STATE OF NORTH CAROLINA  
DEPARTMENT OF TRANSPORTATION

**Addendum No. 1**

RE: Contract ID: C201793

**Haywood County (I-5004)**

DETAIL TO CONVERT EXISTING DROP INLET TO A TRAFFIC BEARING DROP INLET

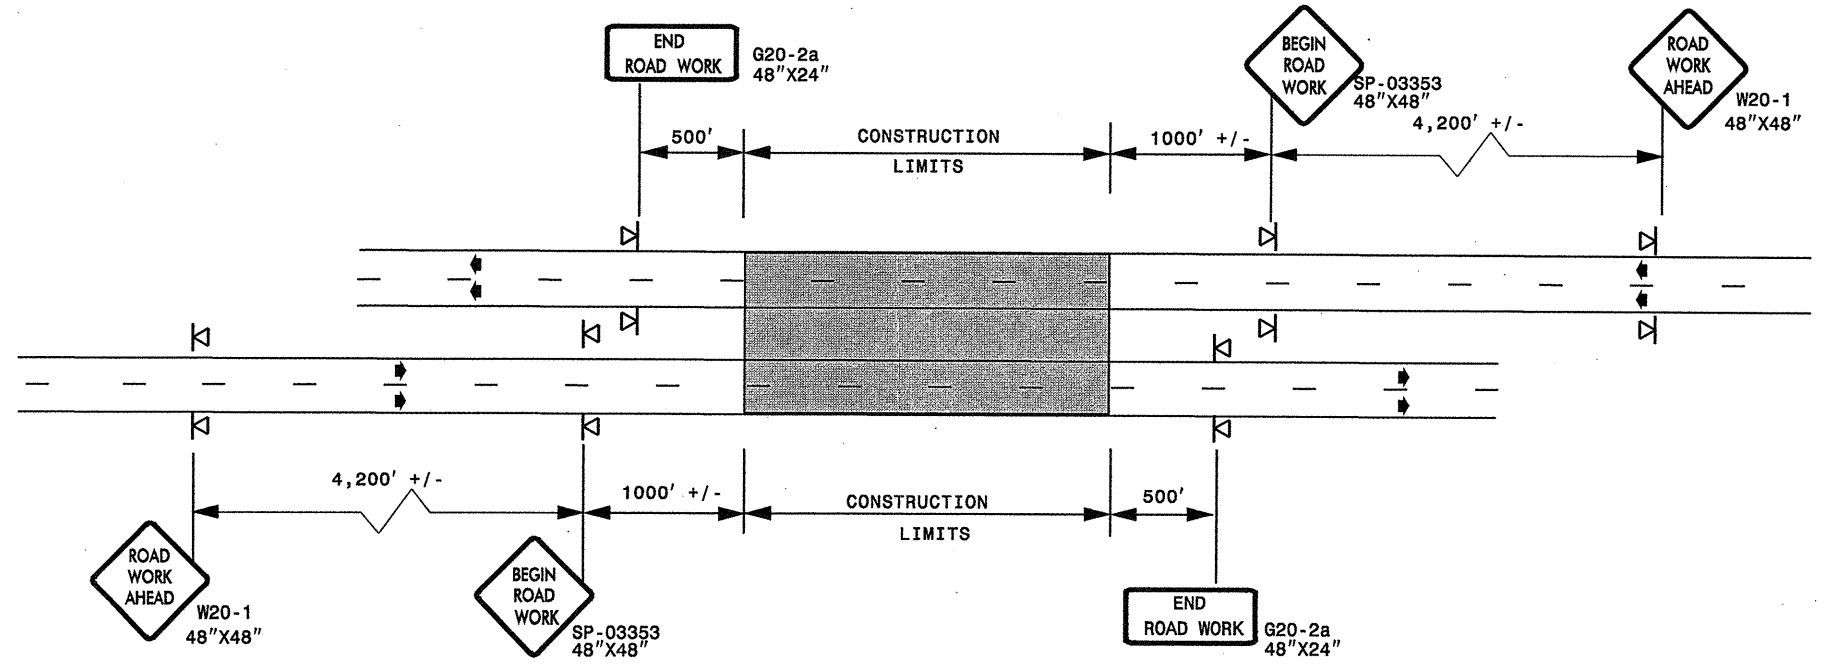
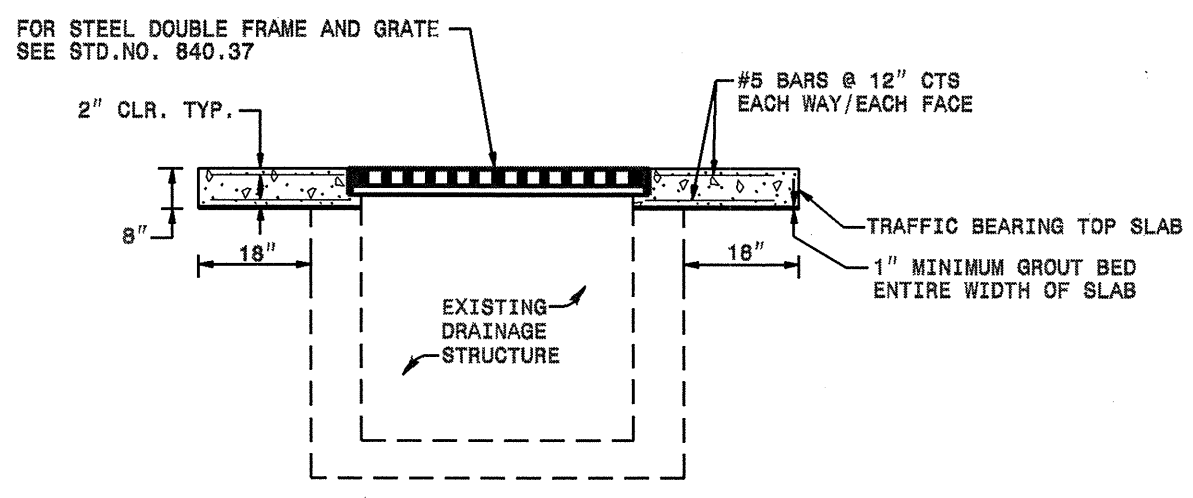
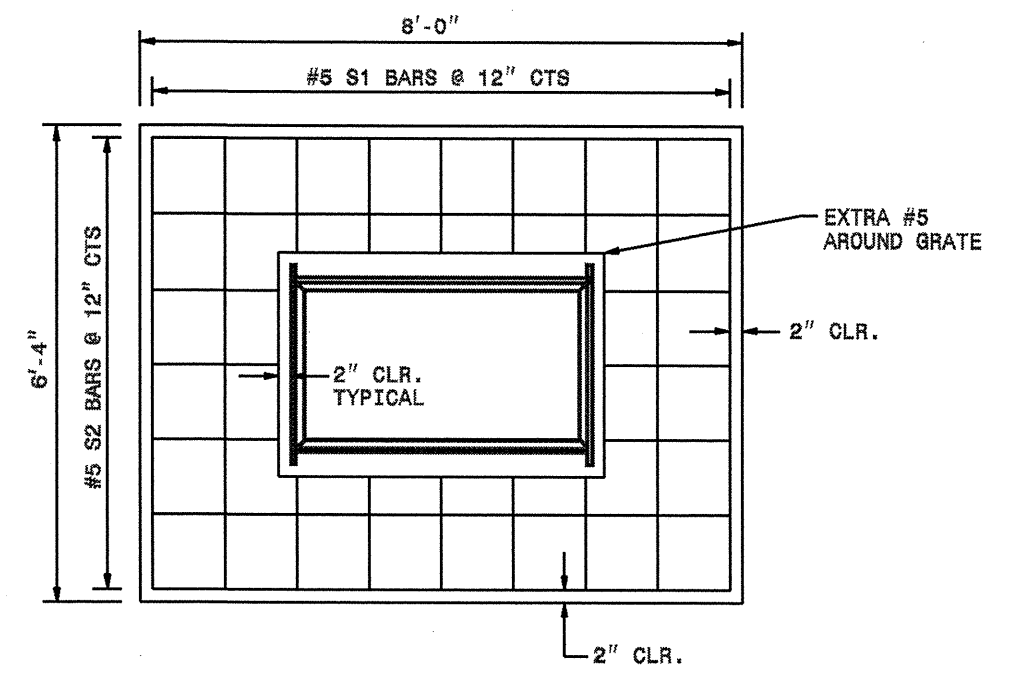
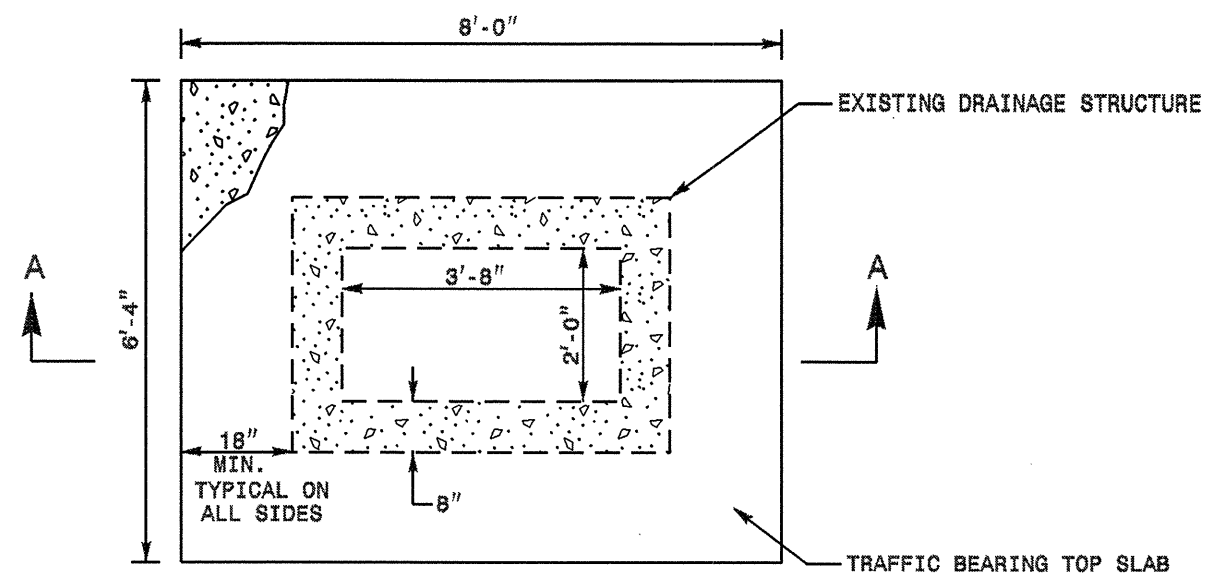
In the project Sketch Maps, after Page No. 8, the Detail to Convert Existing Drop Inlet to Traffic Bearing Drop Inlet has been revised. Please void the current sheet in the Sketch Maps and staple the revised sheet thereto.
